Heyford Park  
Camp Road  
Upper Heyford  
Bicester  
OX25 5HD

17/00973/REM

**Proposal:** Reserved Matters application to 10/01642/OUT - Dorchester Phase 5C, comprising the provision of 17 residential units of mixed type (dwelling houses and flats) and tenure (open market and affordable) with associated landscaping, car parking, infrastructure and external works

LEGEND	
	Shrub Planting
	Hedging
	Tree Planting
	Climbers
	Grass Mown
	Bulbous Planting
	Retained trees
	Green Tech Arborcraft system (or similar approved)

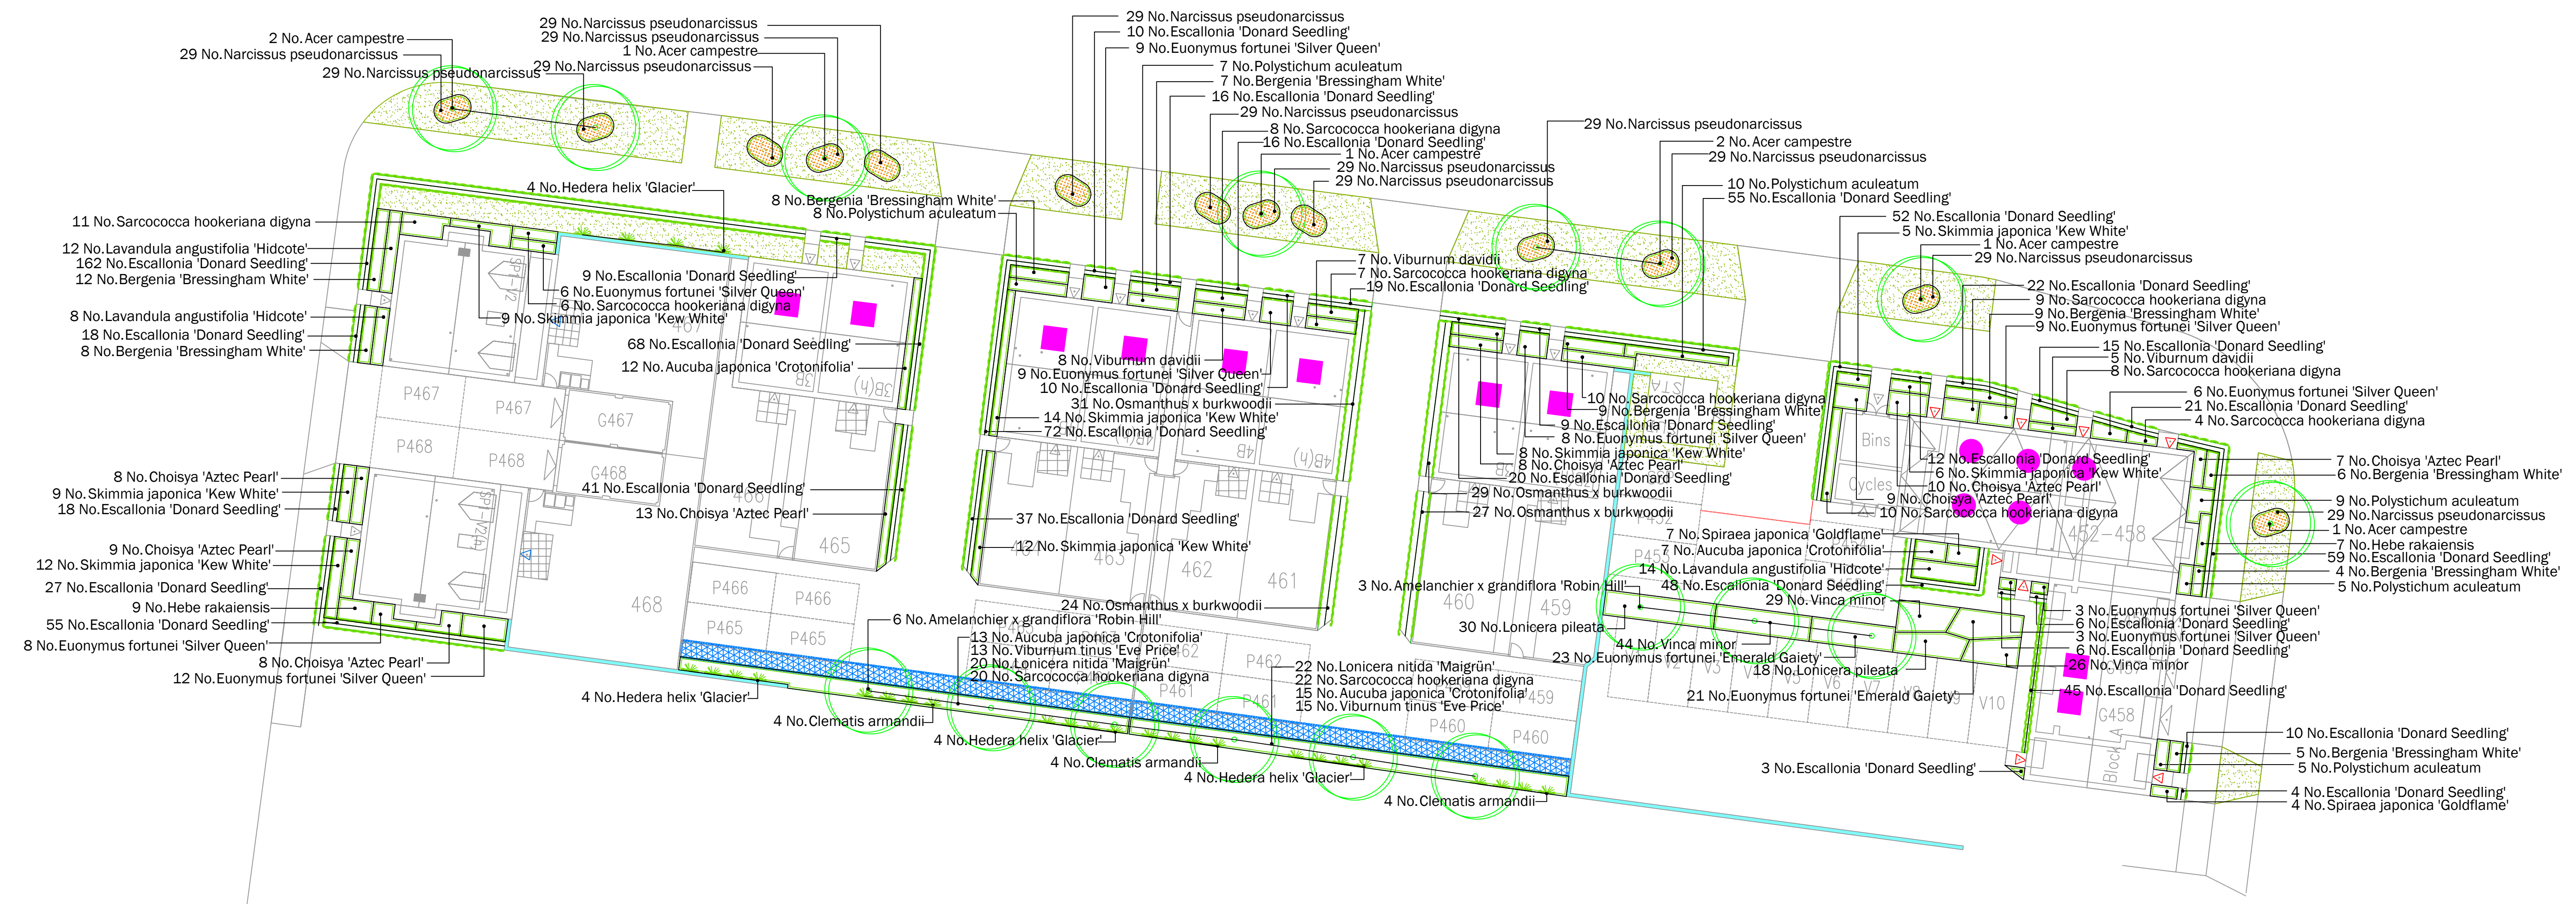
#### 5.6. CDC-Landscape Architect: Detailed Planting Proposals (1619 A8 5C 01 E) are acceptable. Concerned about use of overflow car park.
